Laurie Leader - Re: BP#2014-02322 100 Sheridan Street - Plan review comments

I am handling the plan review for the above property. Can you please address the following questions:

FLOOR PLANS

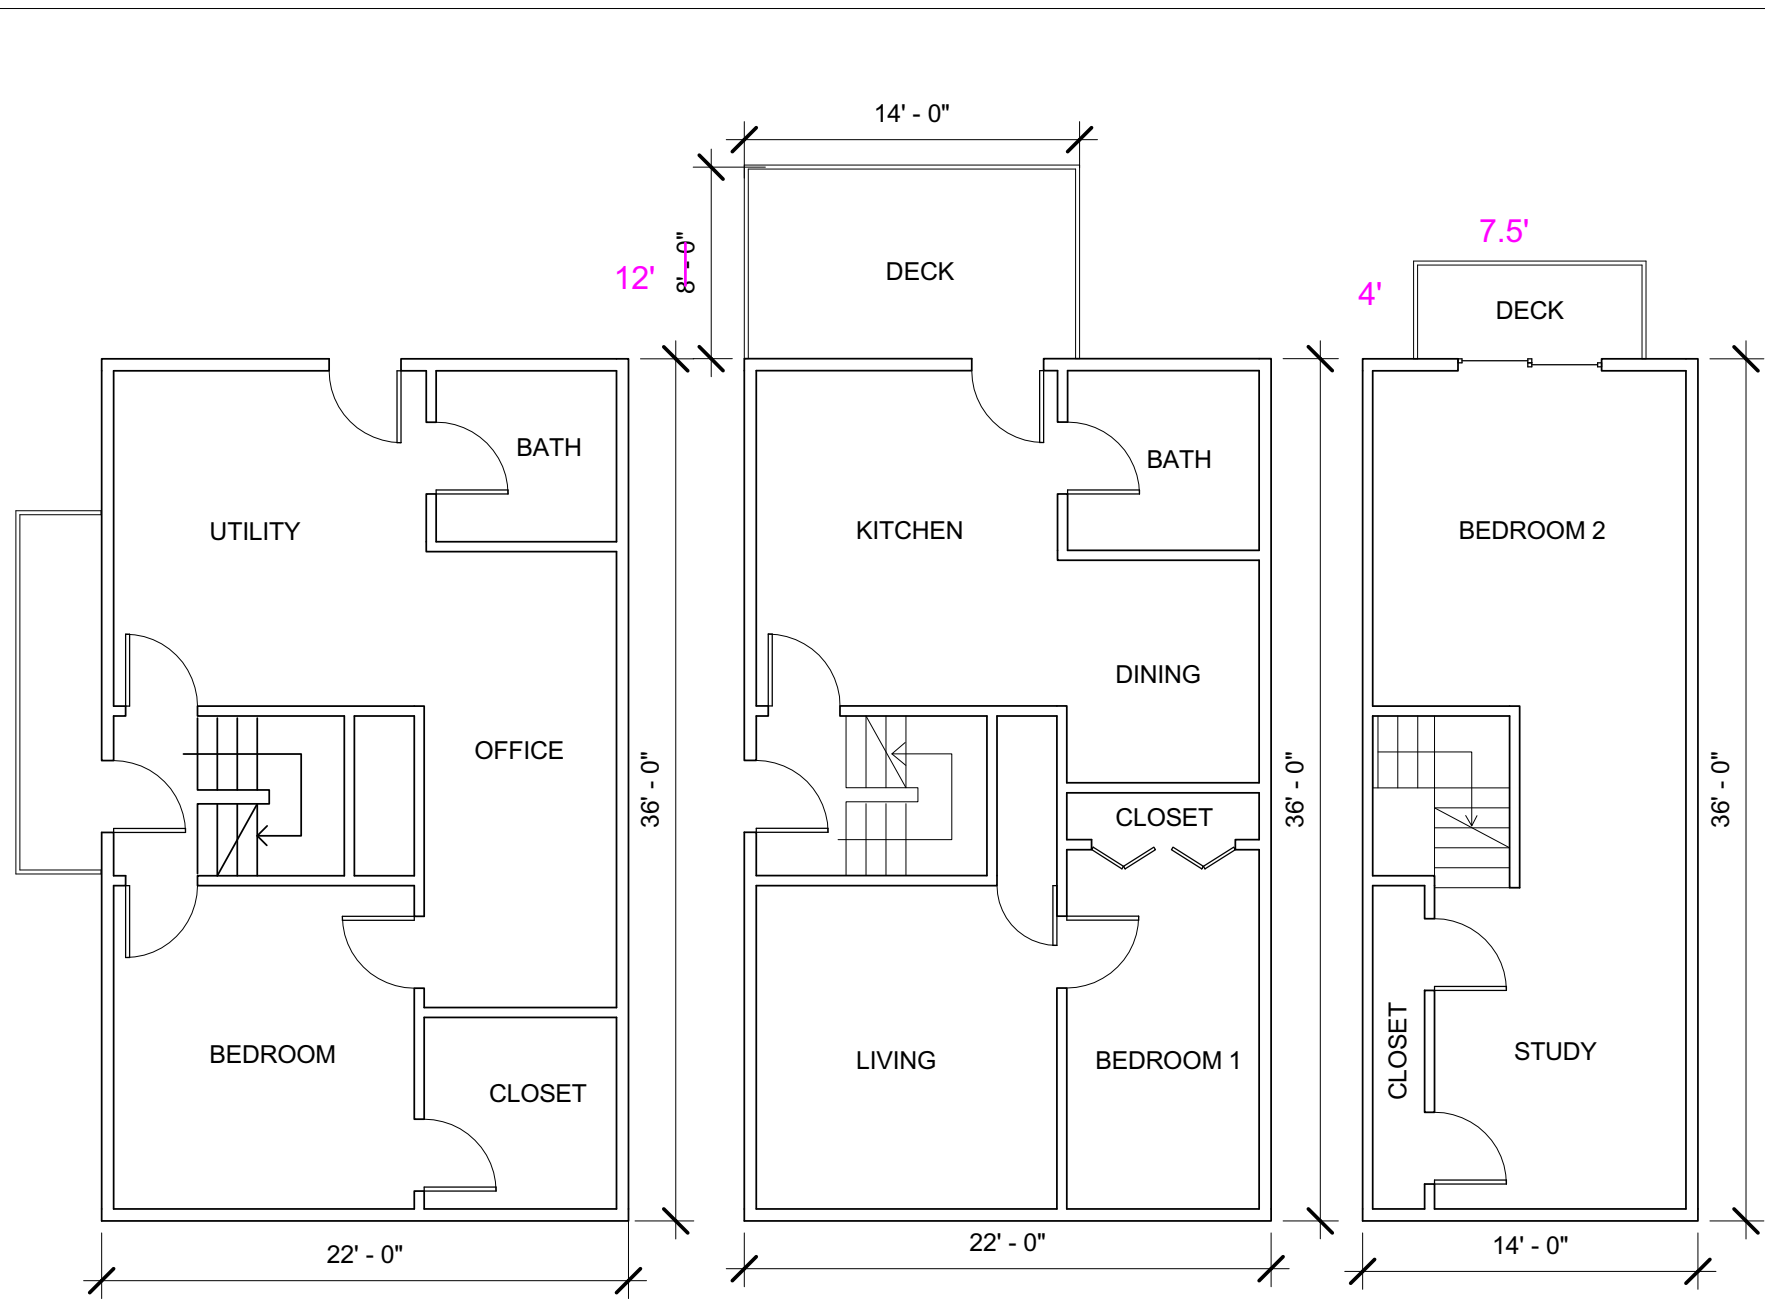
1. If this was two residential units and is being converted into a single family home, can you please clarify if one of the existing kitchens will be removed? Please add to scope of work. What other revisions are being done in the conversion to a single family home?
2. If the existing portico and rear porch are being removed and replaced, this is not clearly spelled out in plans. Please revise plans to clarify existing versus proposed work.
3. Once scope of work is clarified, revise cost of construction. Cost of construction seems very low for the installation of a reach porch and portico.

1. We are removing the kitchen appliances from the 1st floor apartment. there will be no other work needed as the building lays out as a three bedroom two bath house. The old kitchen will become the laundry room. I have included a floor plan that shows the layout, without us having to do any interior work.
2. The rear decks are existing and no work is being done to them.
3. The front portico is being cut back 3' in width, three new posts with piers and a single ply roof will be installed.
